**From:**Mitul Patel - Brophy Riaz & Partners Ltd  
**Sent:**Tue, 11 Jan 2022 17:30:30 +0000  
**To:**Osborne, Lawrence (Places Directorate - Solihull MBC)  
**Subject:**RE: PL/2021/03050/COU - Roundmead Day Centre, Crabtree Drive.  
**Attachments:**3439-01-E.pdf

**From:** Osborne, Lawrence (Places Directorate - Solihull MBC) <losborne@solihull.gov.uk>  
**Sent:** 06 January 2022 11:35  
**To:** Mitul Patel - Brophy Riaz & Partners Ltd <m.patel@brp.uk.net>; Maria Sharp - Brophy Riaz & Partners Ltd <m.sharp@brp.uk.net>  
**Subject:** PL/2021/03050/COU - Roundmead Day Centre, Crabtree Drive.

drawing:
**PROPOSED CHANGE OF USE TO
 OFFICE – ELEVATIONS**

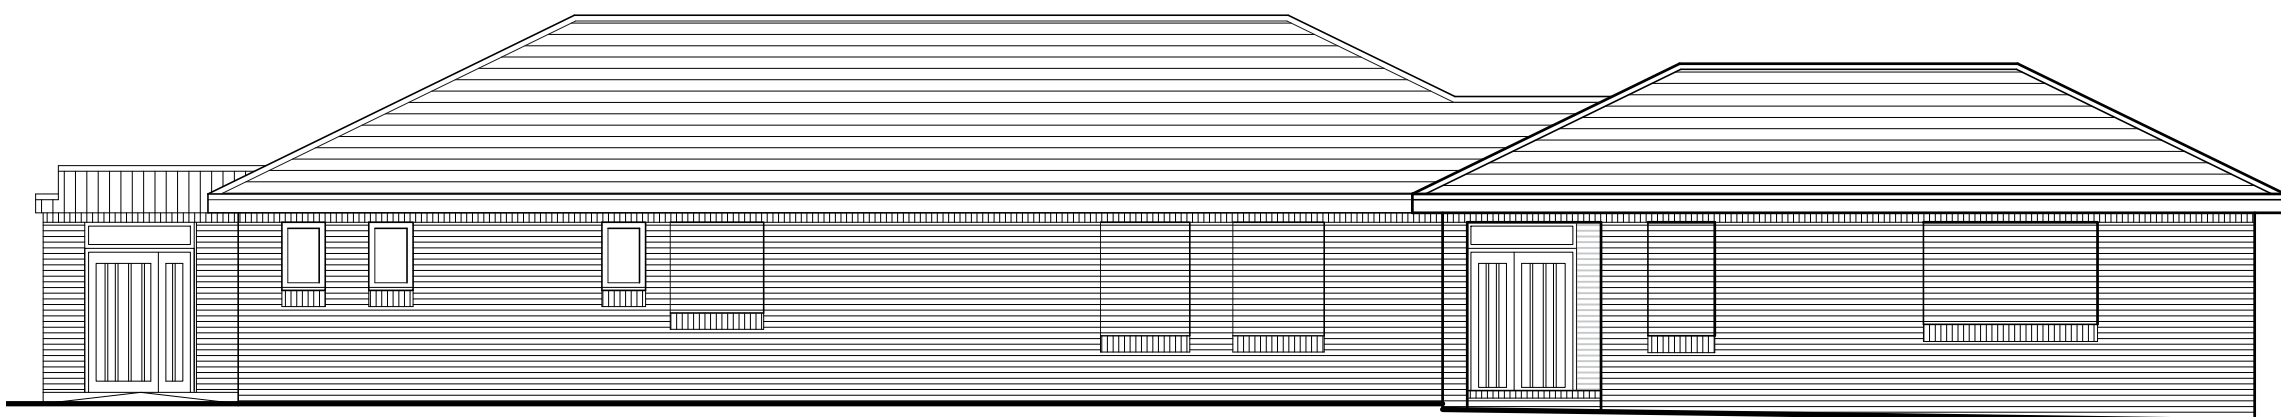
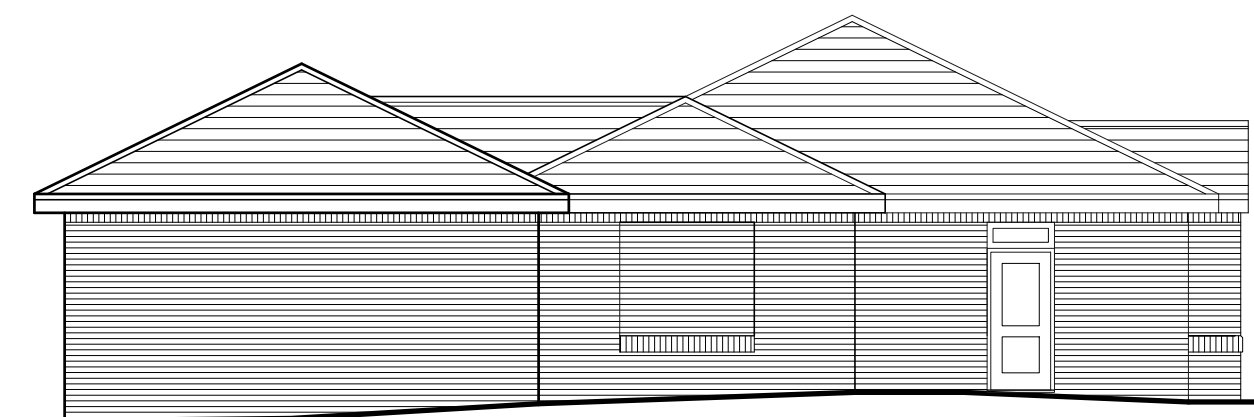
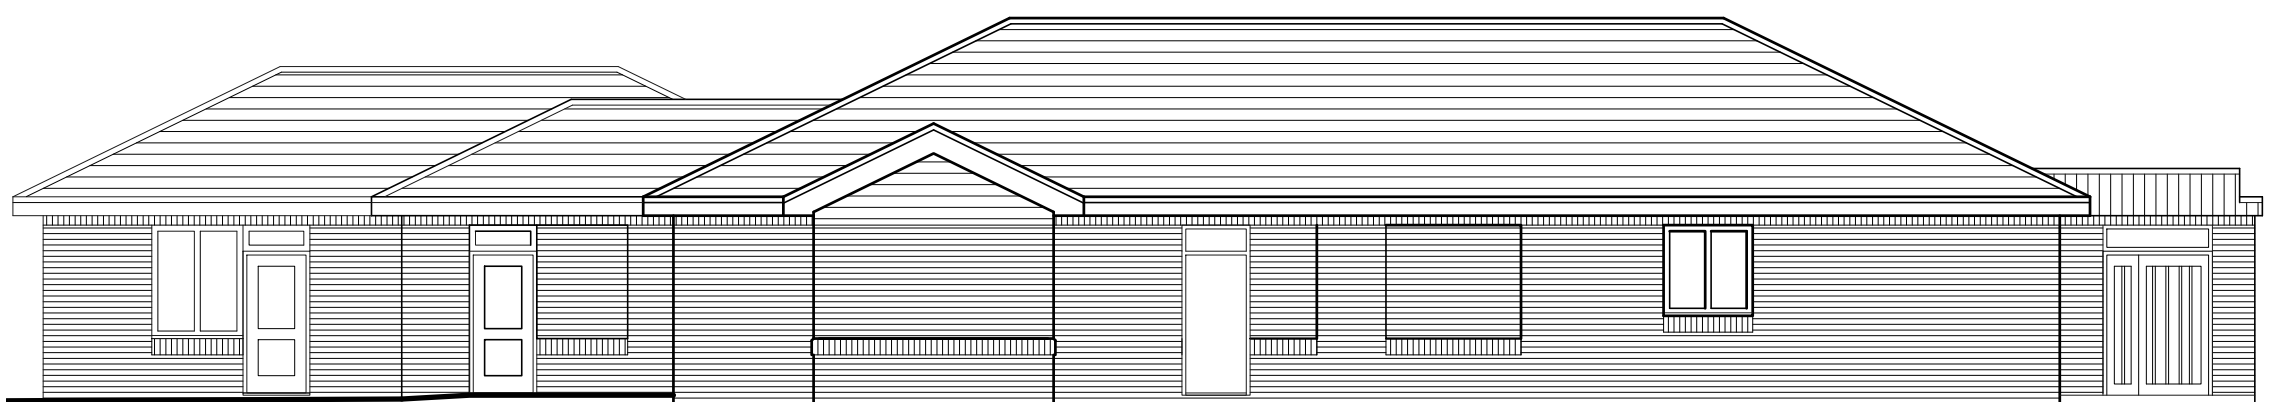
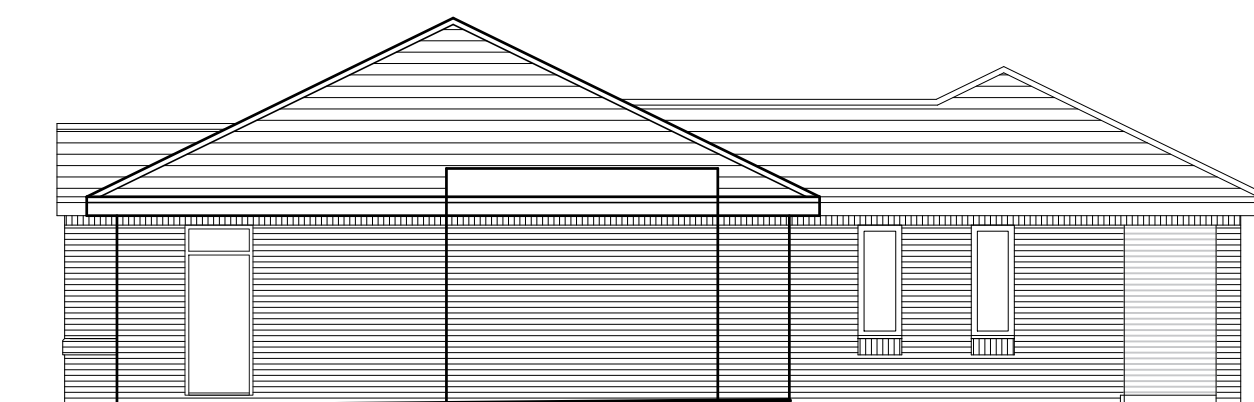
1.The external appearance of the building is proposed to change with a significant number of windows proposed to be bricked up – why? Do the retained windows provide for sufficient natural light for an office use and provide sufficient circulation of air to meet a modern office standard?

We are proposing to block up windows for reasons of overlooking and security for the specific type of office use that we discussed at the time of registration. Removing windows from the main work area also assists with limiting solar gain and temperature control. Lighting and ventilation will be by artificial means. The position of the building in the shadow of Bosworth Medical centre means it is only visible to a limited number of residents and it has little contribution to the public realm. However, I agree that blocking up of the majority of windows would result in an austere elevation and I would propose these relevant windows to have a inset brick panel in place of the widow – note added to amended drawing attached.

PROPOSED GROUND FLOOR PLAN 1:100

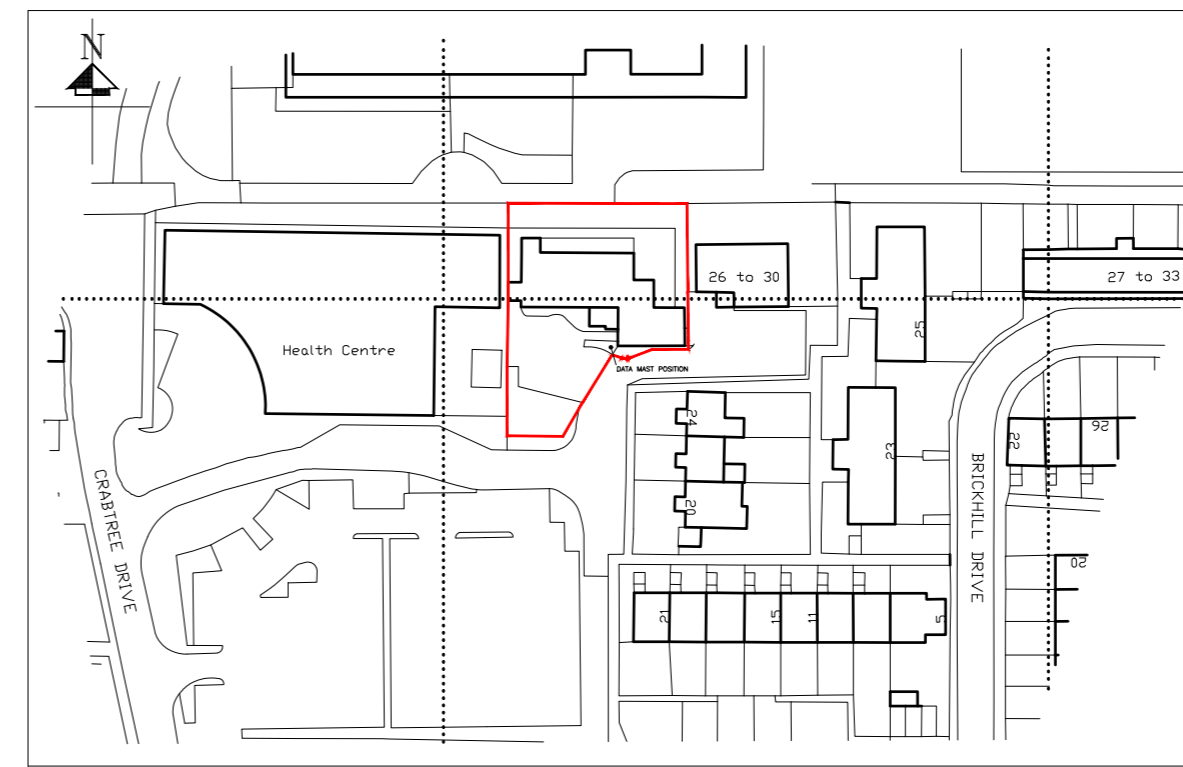
2.The building floor plans show that all existing w/c and welfare facilities are removed – without such provision can the proposed use as Class E offices function for such a purpose?

For the same security reasons mentioned above, we had ‘blanked out’ the proposed floor plan. Welfare facilities will be provided and retained in their existing positions. The floor plan has been amended to reflect this.

DATA MAST 1:100

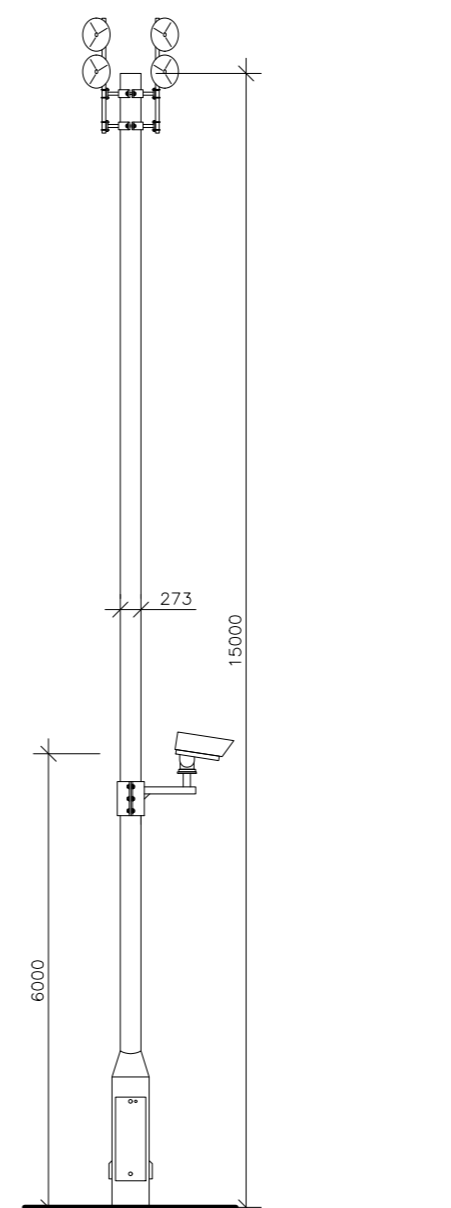
1.What is the purpose of the mast?

2. Is the mast similar to a mobile telephone mast is the mast? If so is the mast ICNIRP (International Commission on Non-Ionizing Radiation Protection) compliant in respect of health and safety requirements for local residents adjacent to the site?

The purpose of the mast was to receive data from sites across the borough. However, following further reviews of current technologies we have decided not to use a mast and instead use fibre optic cables to receive the data. The mast has been removed from our amended drawing attached.
